Internet Ref: ECH1065
Our Ref: BE/127/12/A
Case Officer:
Mr C Cronin

Various non-illuminated & internally illuminated signage
Former LEC Site Shripney Way Bognor Regis

The Planning and Licensing Committee discussed the Sainsbury's Planning Application, BE/127/12/A at their meeting on the 18th December 2012. Please find their comment below:

Proposed Welcome Wall & Vinyl Details

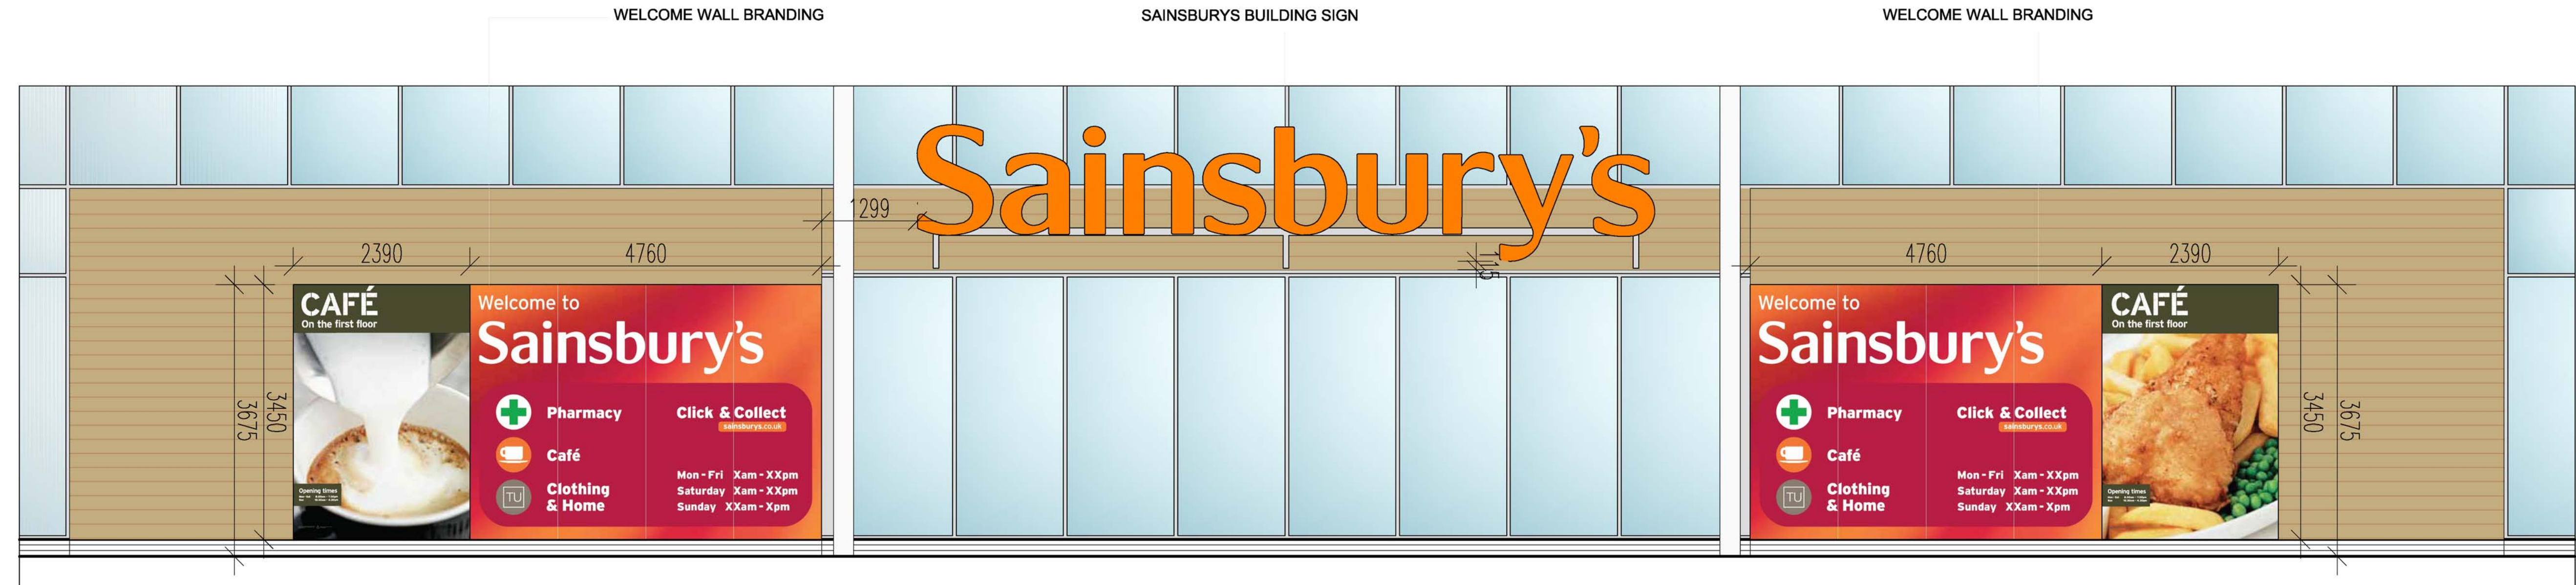
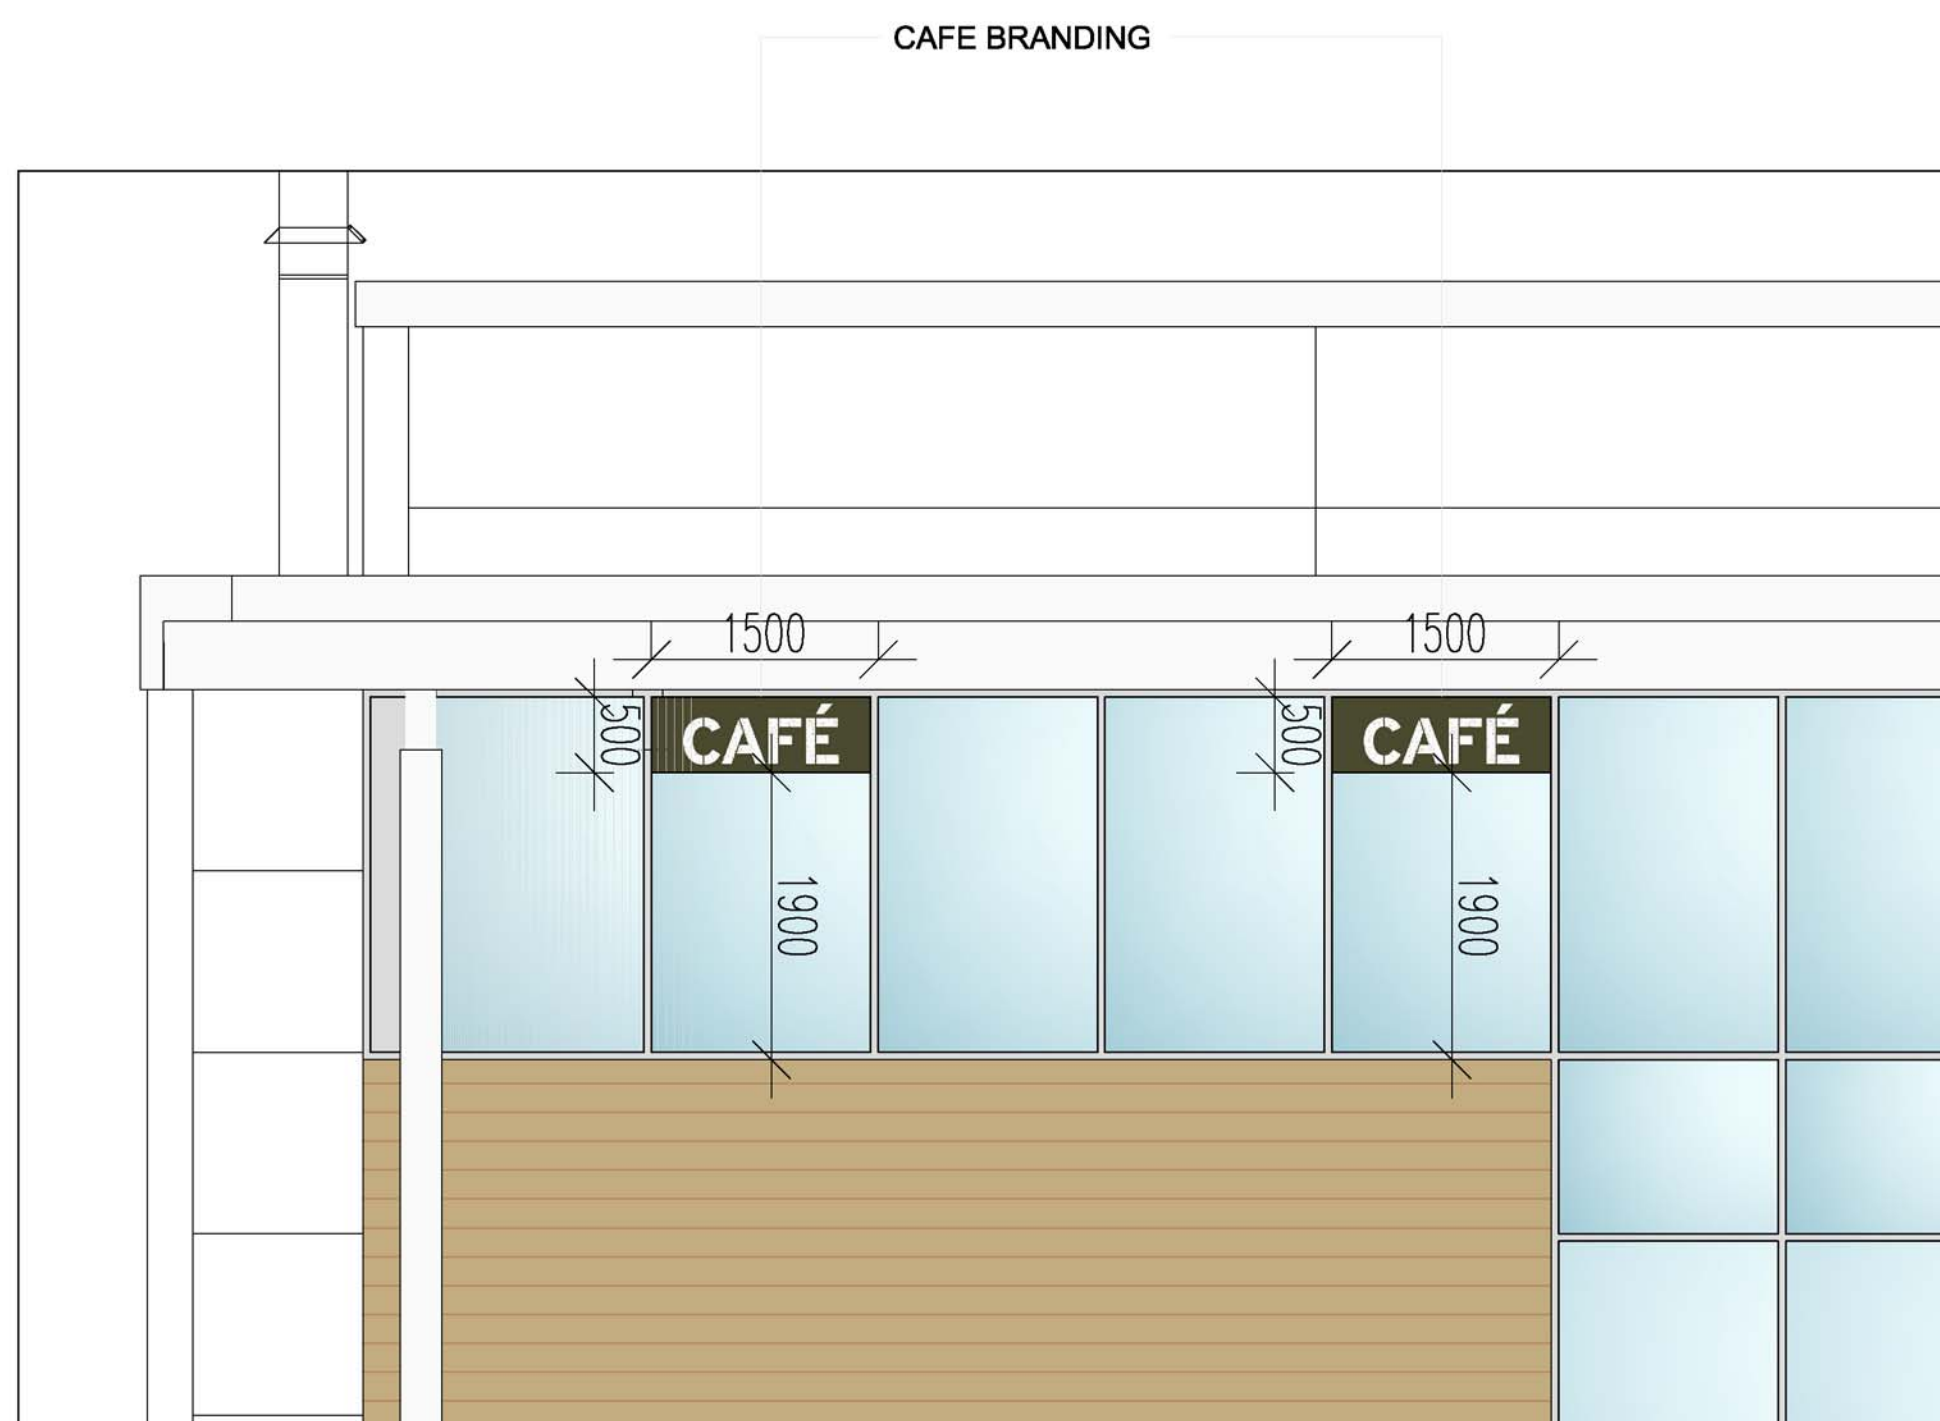
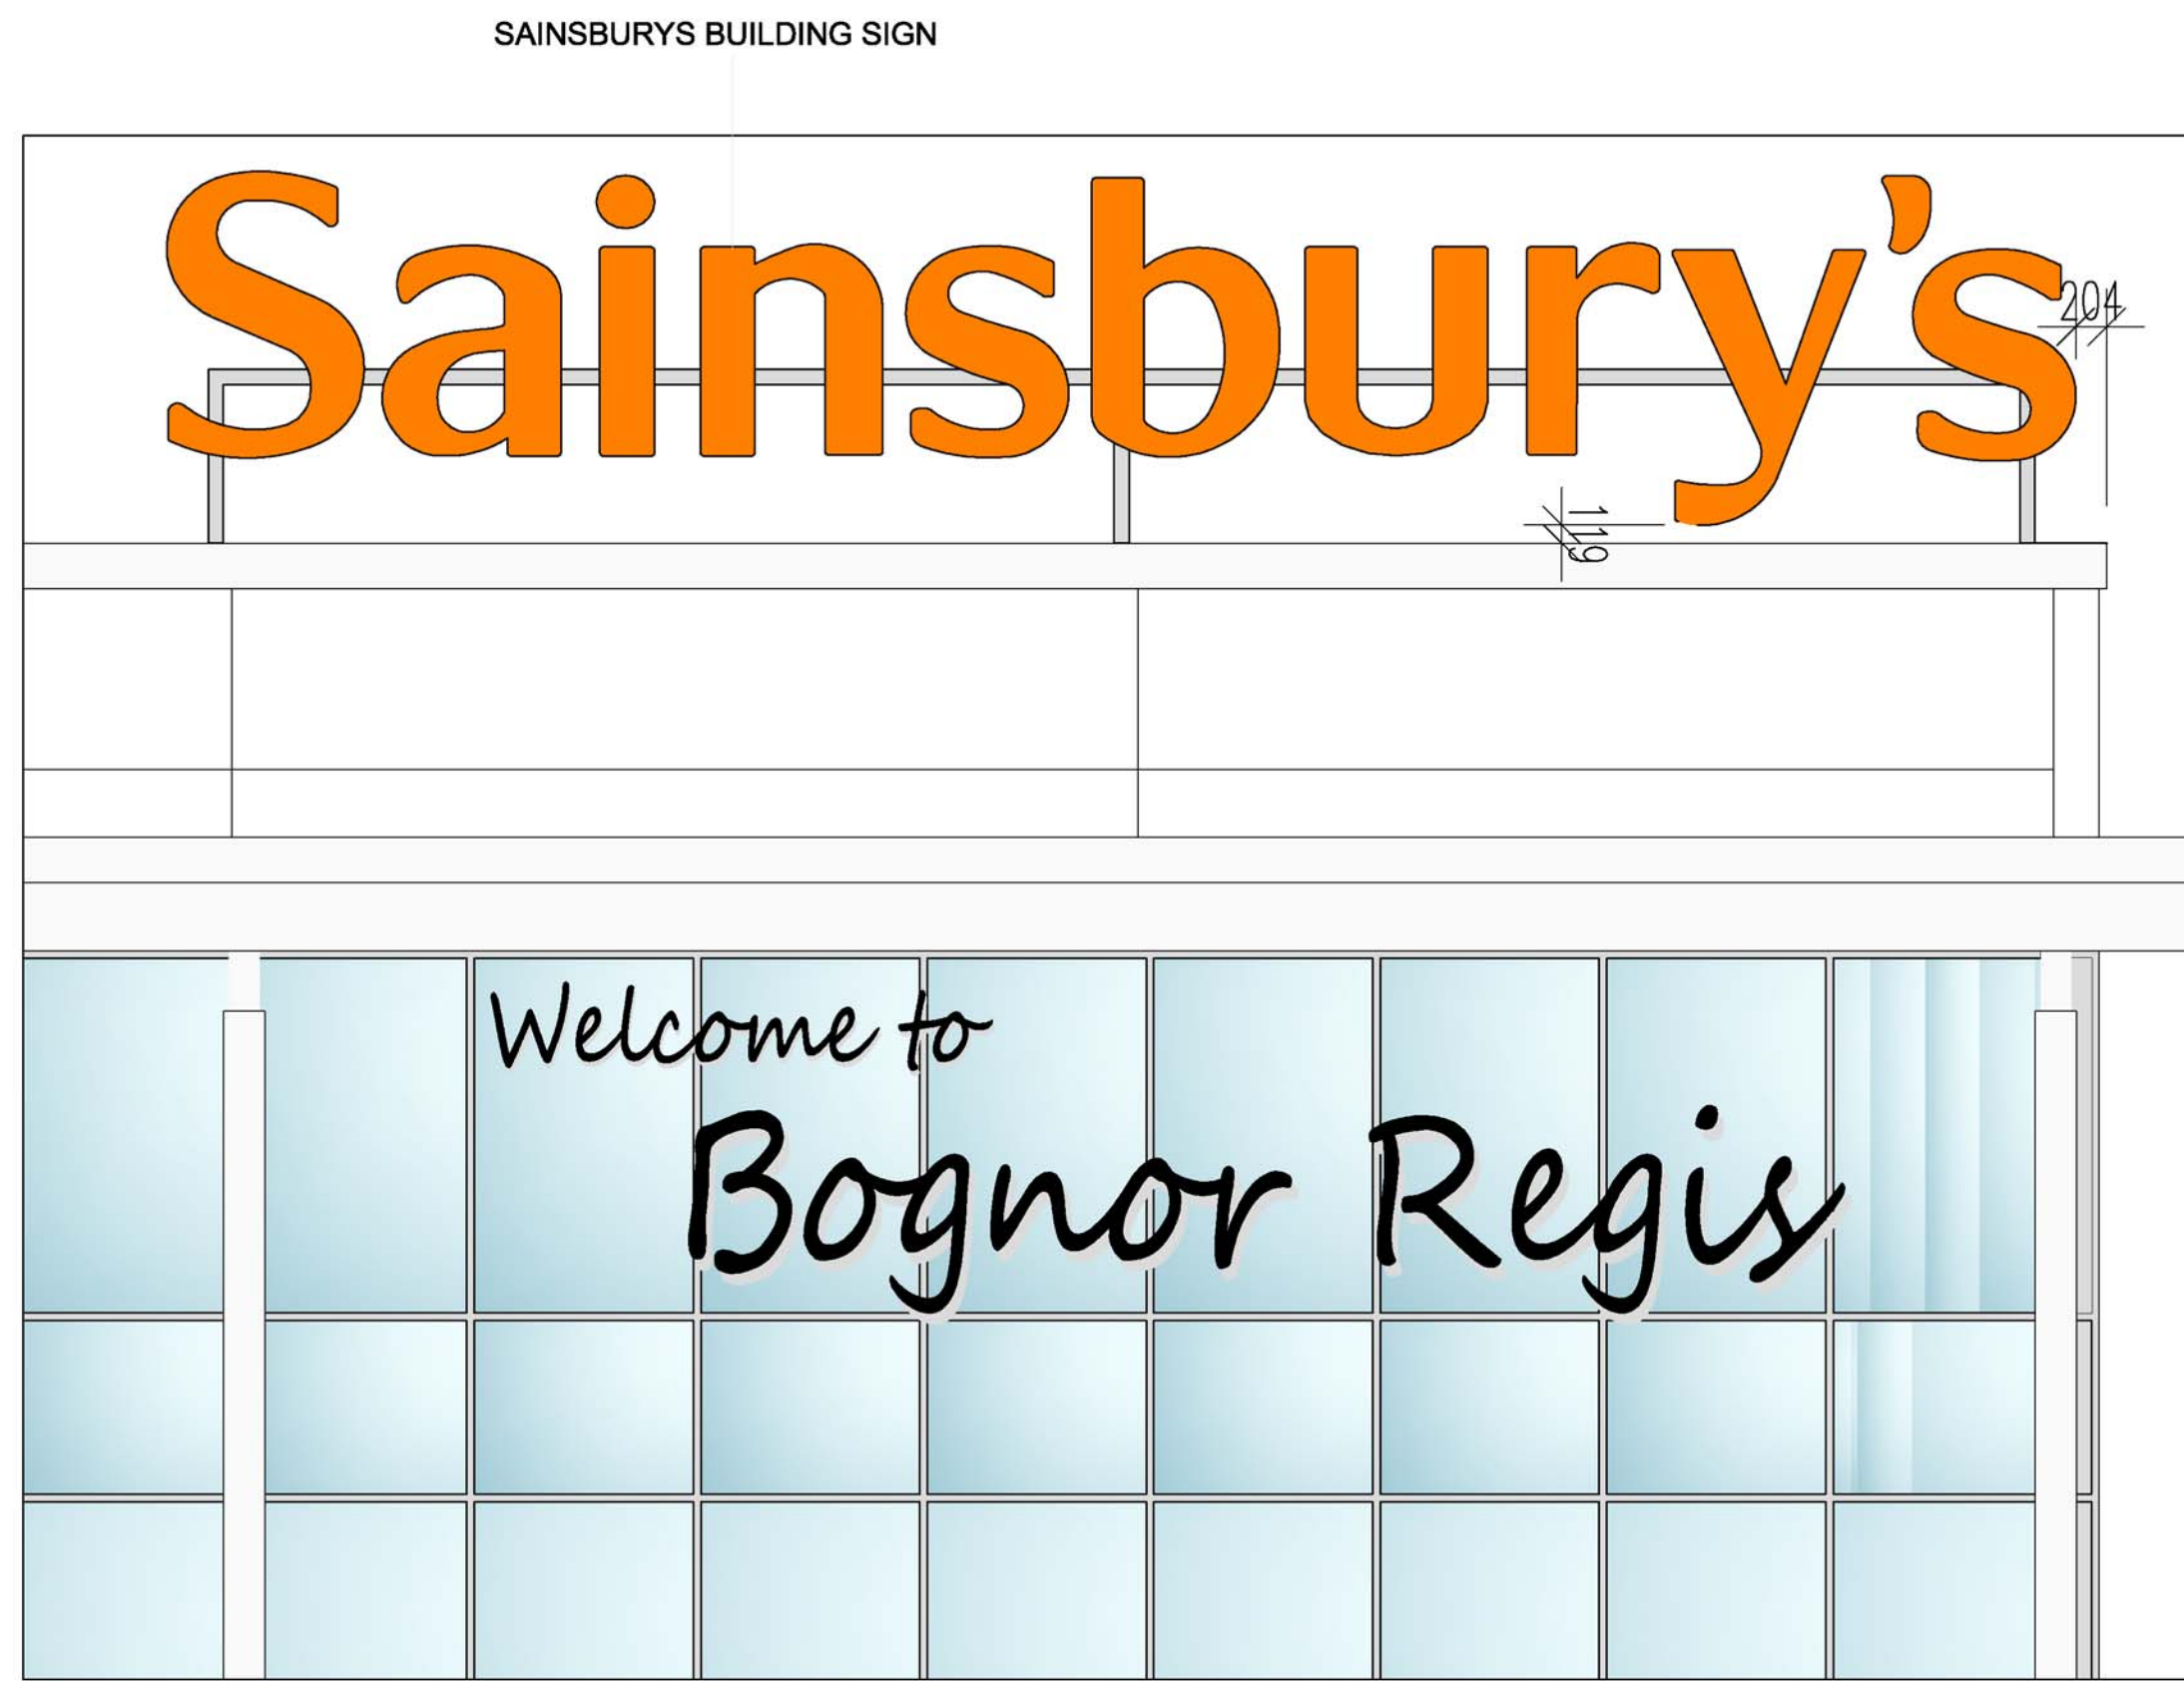
NO OBJECTION but the Committee expressed their disappointment that the 'Welcome to Bognor Regis' is not more prominent as had been previously promised
